Subject: RE: Planning Consultation on: LU/42/21/PL

Engineers Comments Regarding Surface Water Drainage

Application No: LU/42/21/PL

Site Address: Riverside Industrial Estate Bridge Road Littlehampton BN17 5DF
Grid Reference: 501774 102469
Description of Works: Erection of 1 No. industrial unit (Use Class B2/B8), associated parking & landscaping. This site is in CIL Zone 4 (Zero Rated) as other development.

Appendix F – Proposed Drainage Layout

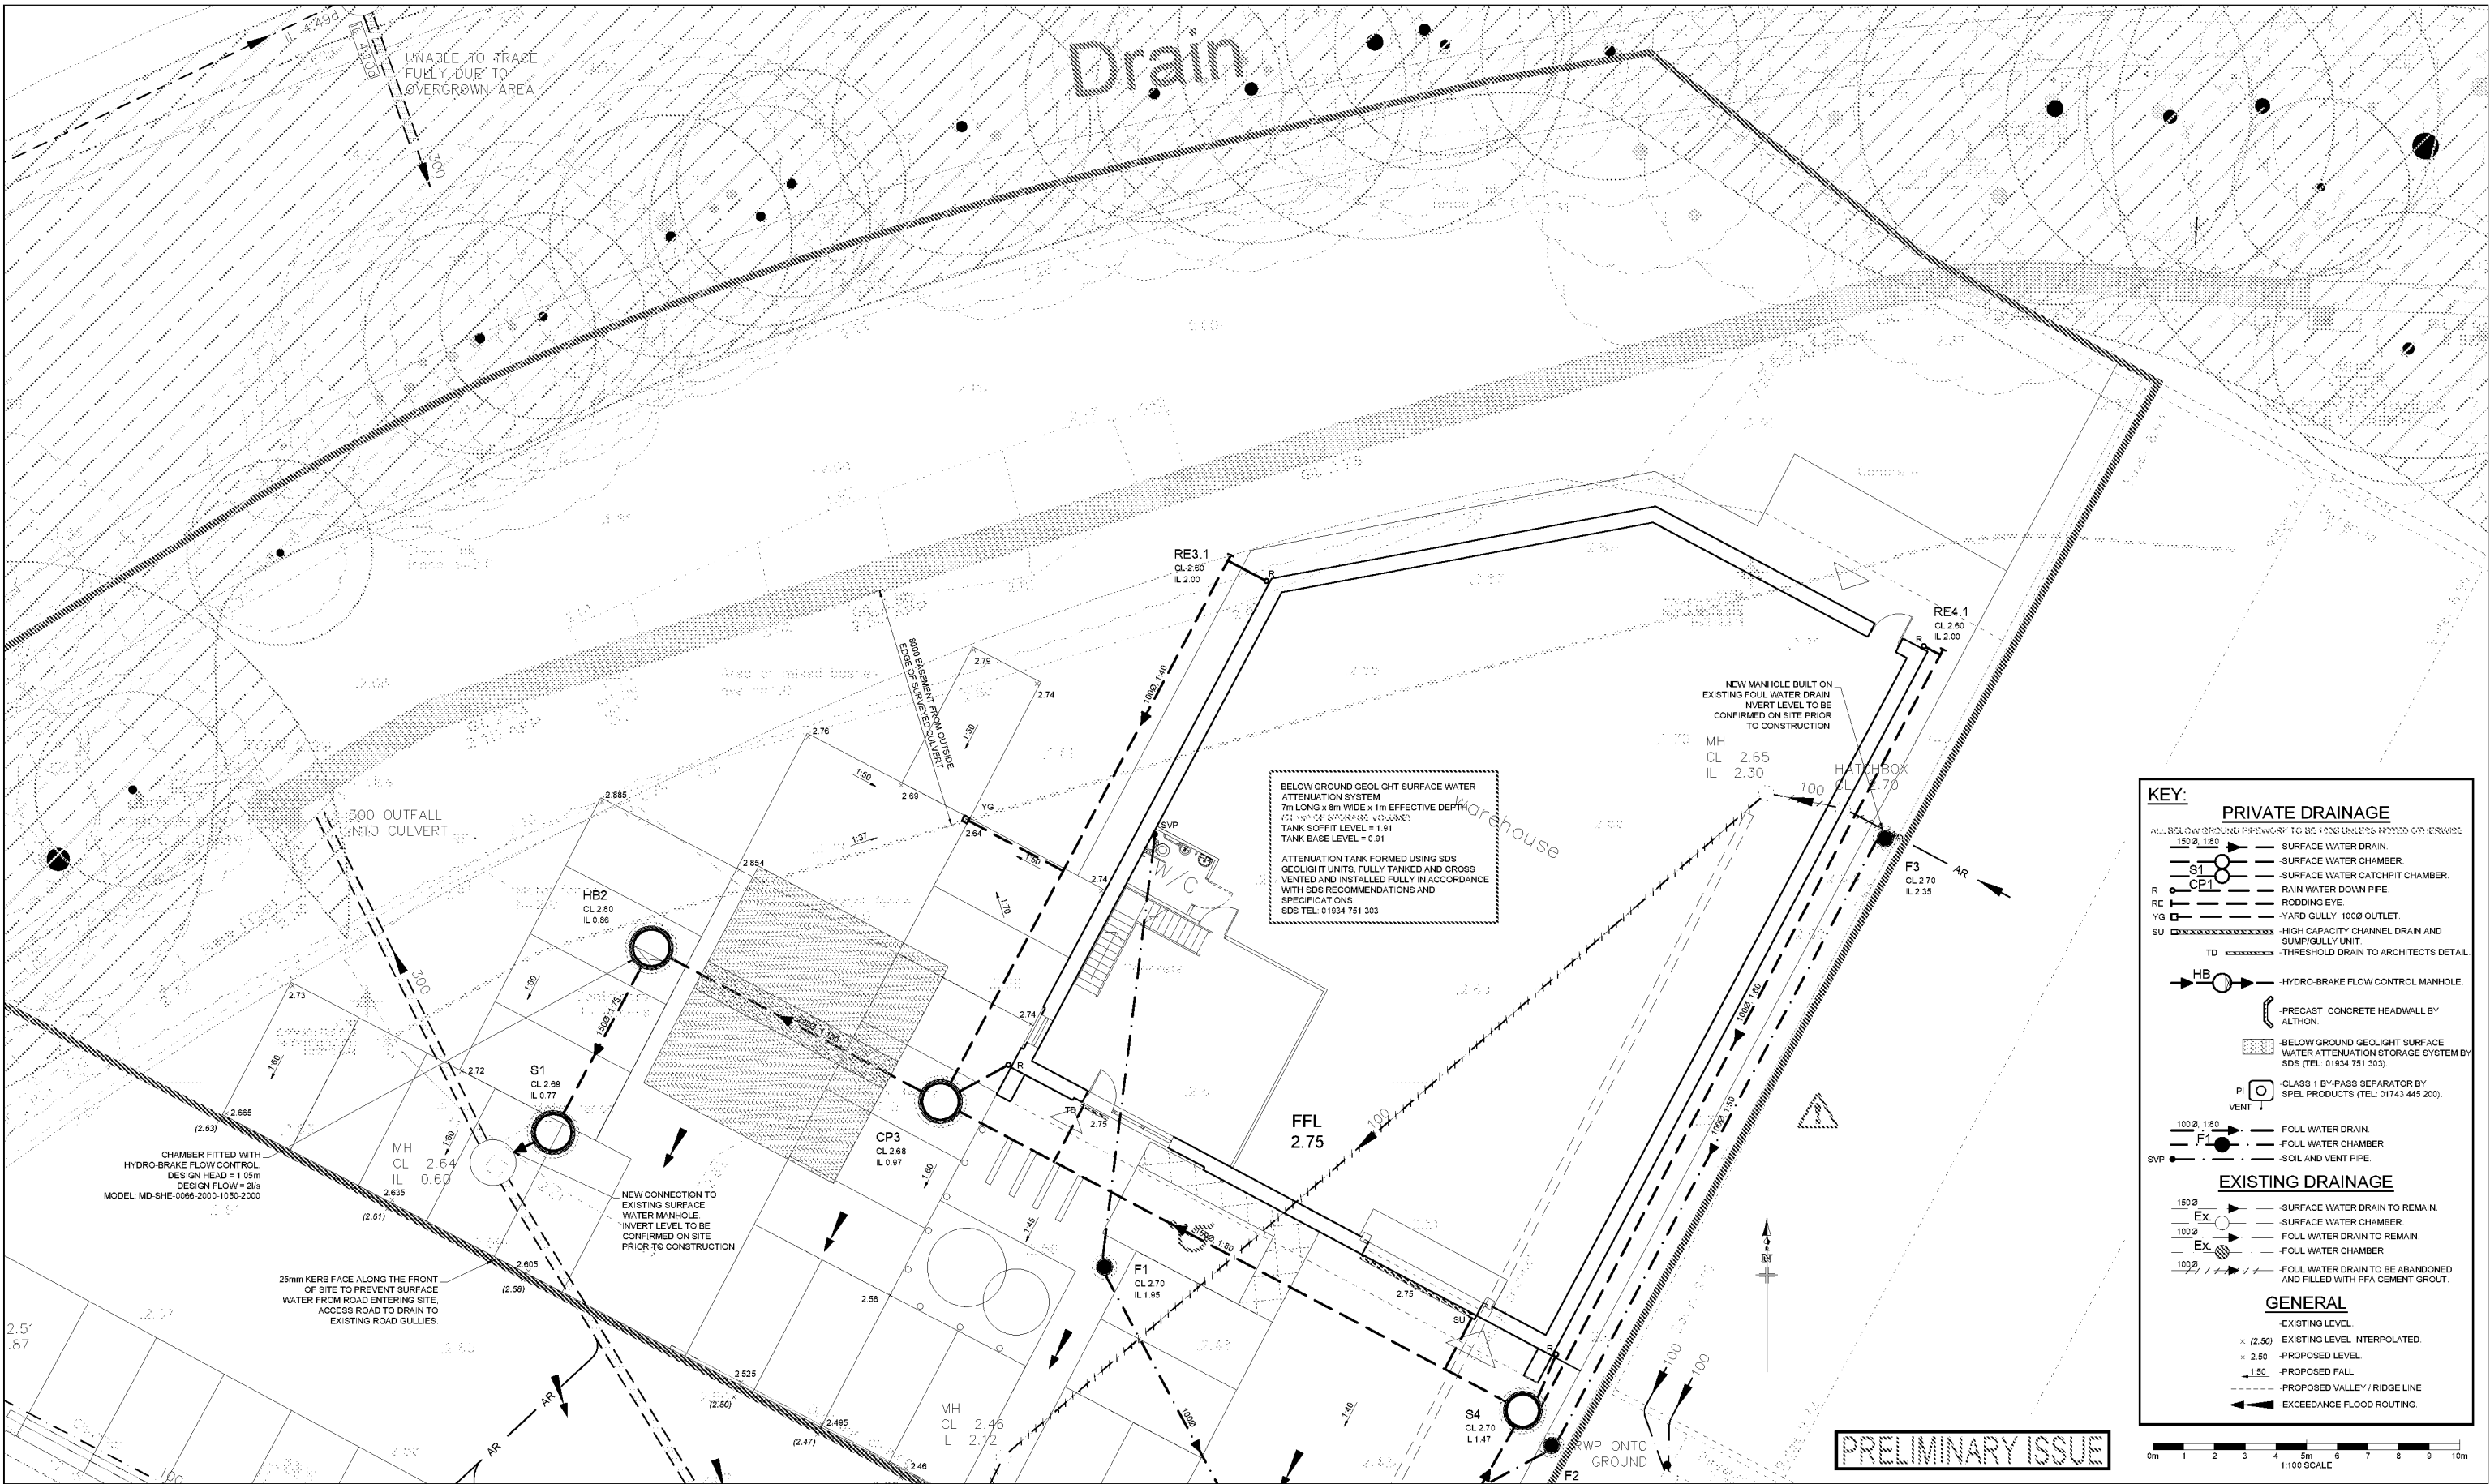
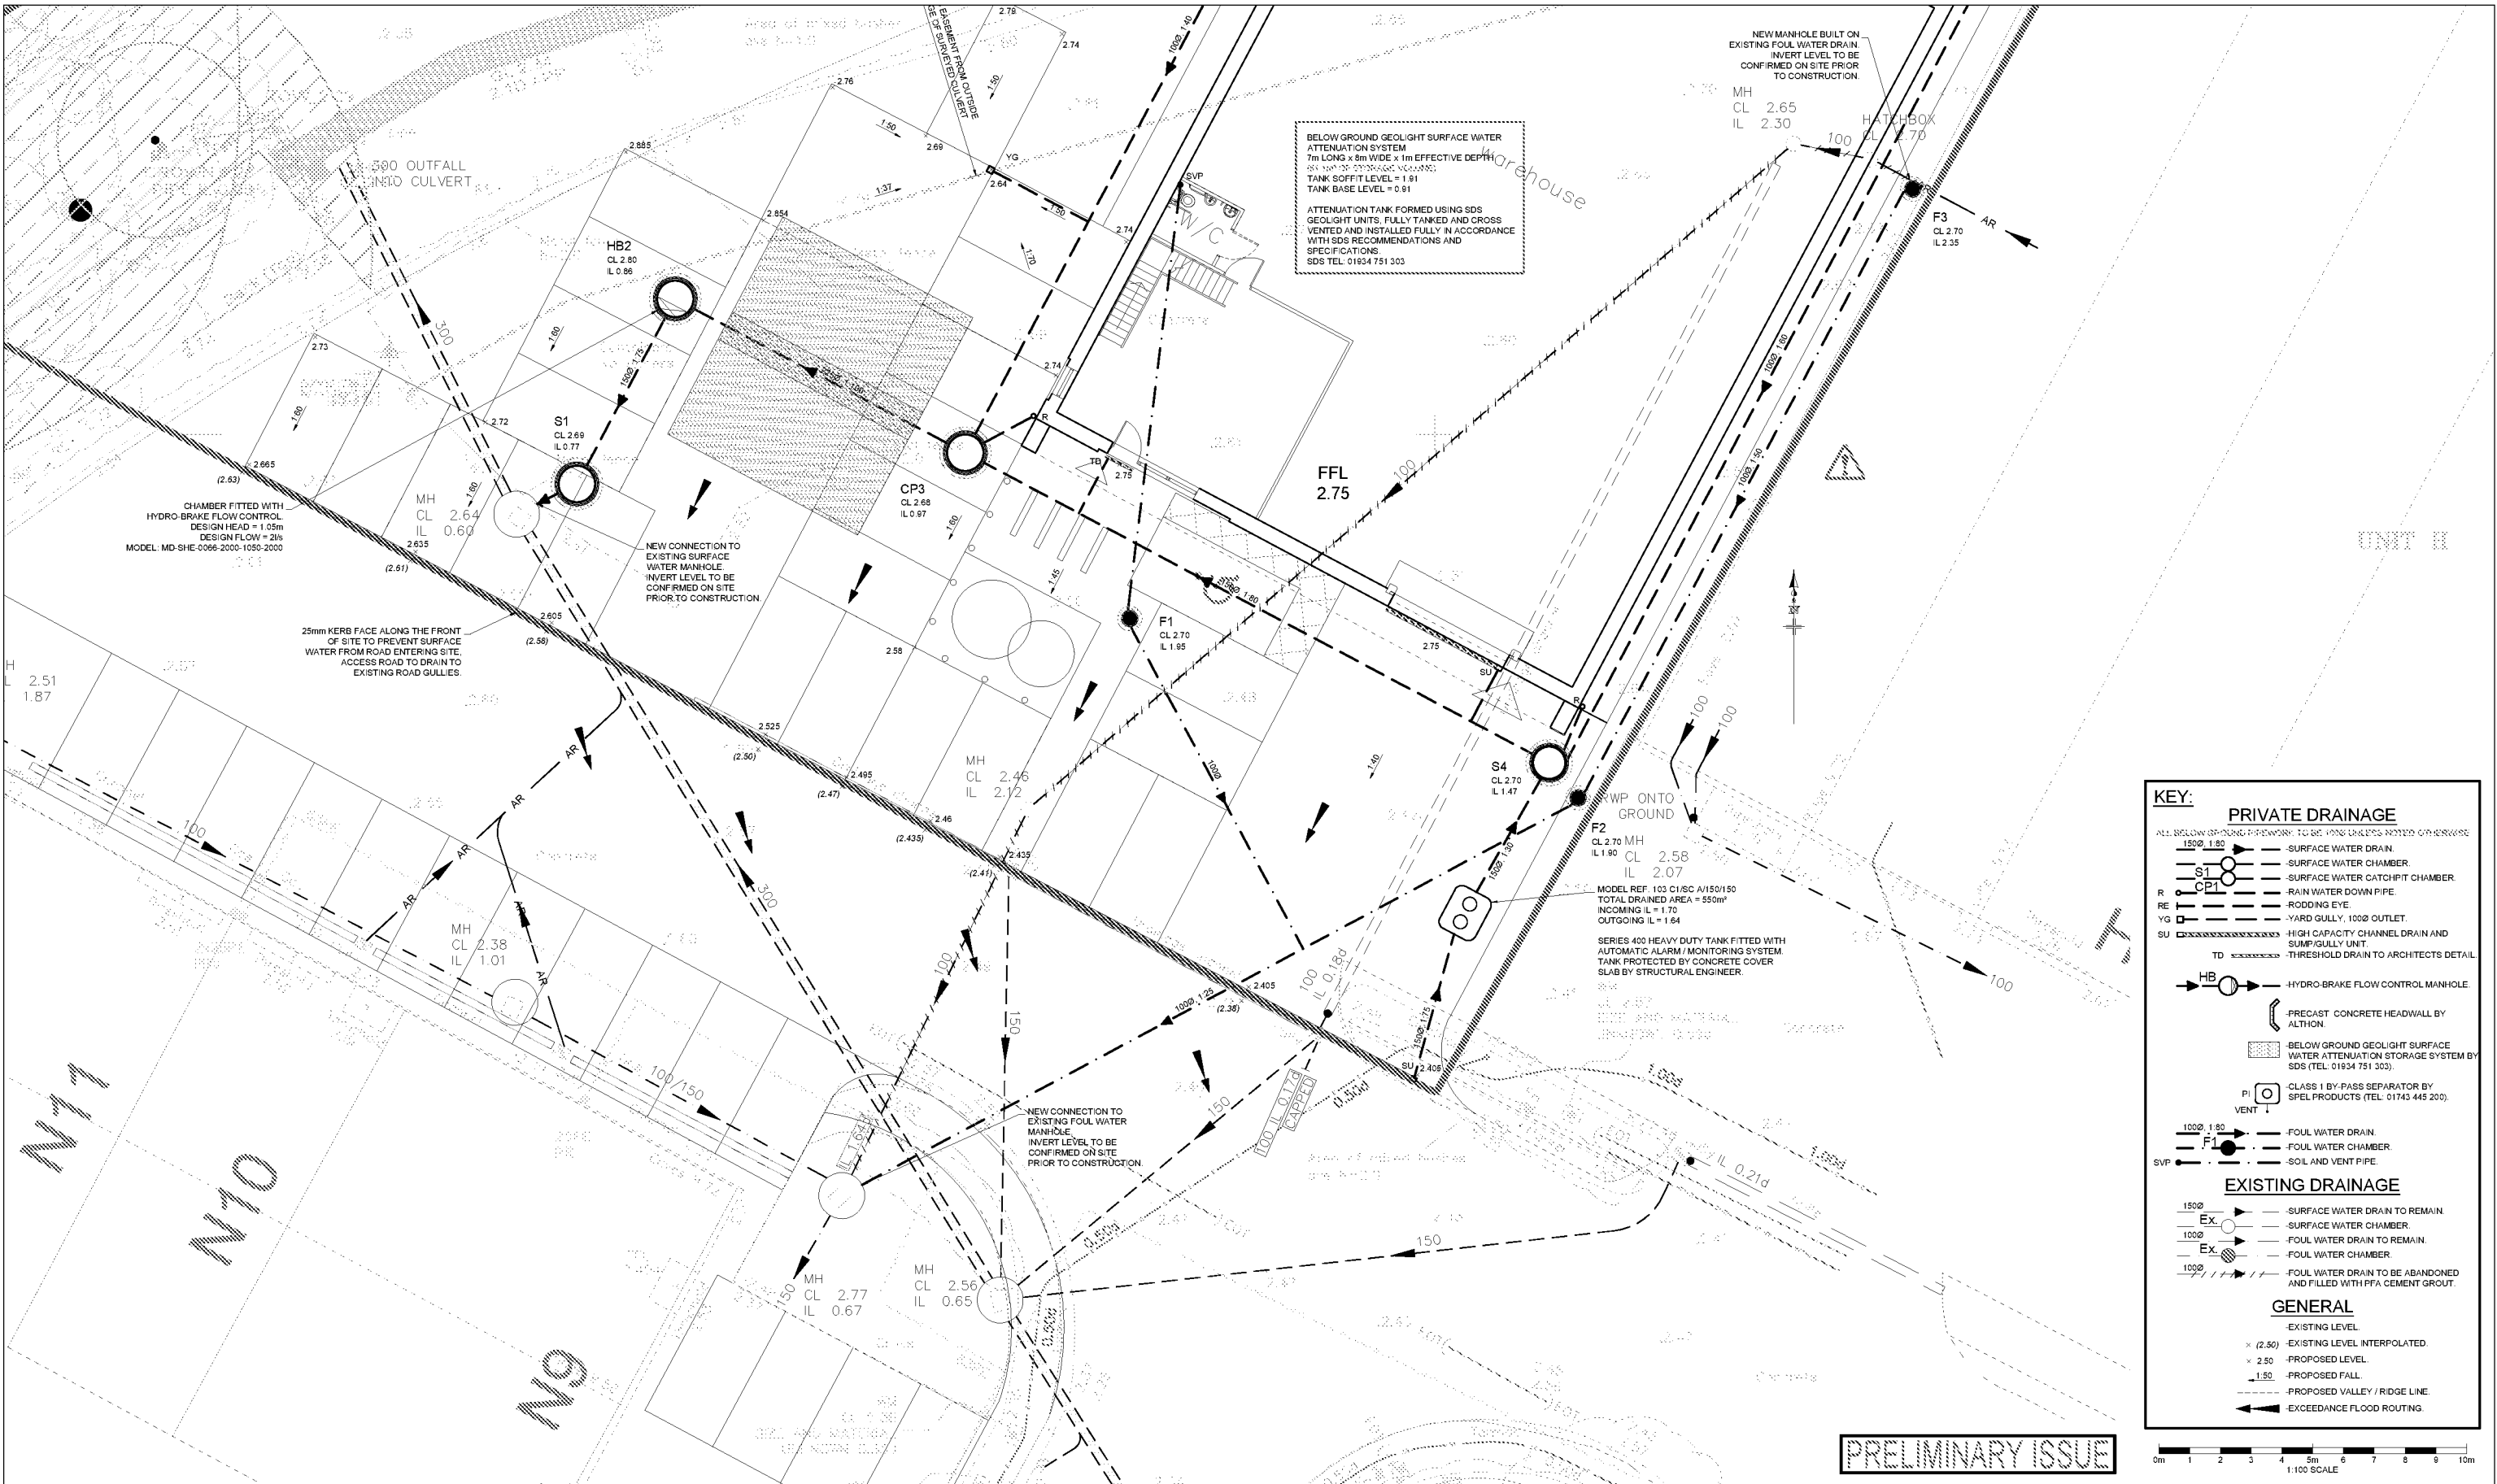
It is noted that the applicant has supplied an FRA and a surface water drainage strategy. The general principle of the proposals are reasonable, although it seems that no groundwater monitoring has been completed on site (relying on borehole data). We would encourage the applicant to either undertake groundwater monitoring or consider groundwater to be at surface in their calculations to account for the buoyancy (for the attenuation tank).

There is a risk that the existing surface water drainage pipes may not be fit for purpose (to receive additional surface water flows). These should be thoroughly investigated and improved if necessary. In addition, the surface water drainage system should be designed for a surcharged outfall as the site lies within Flood Zone 3.
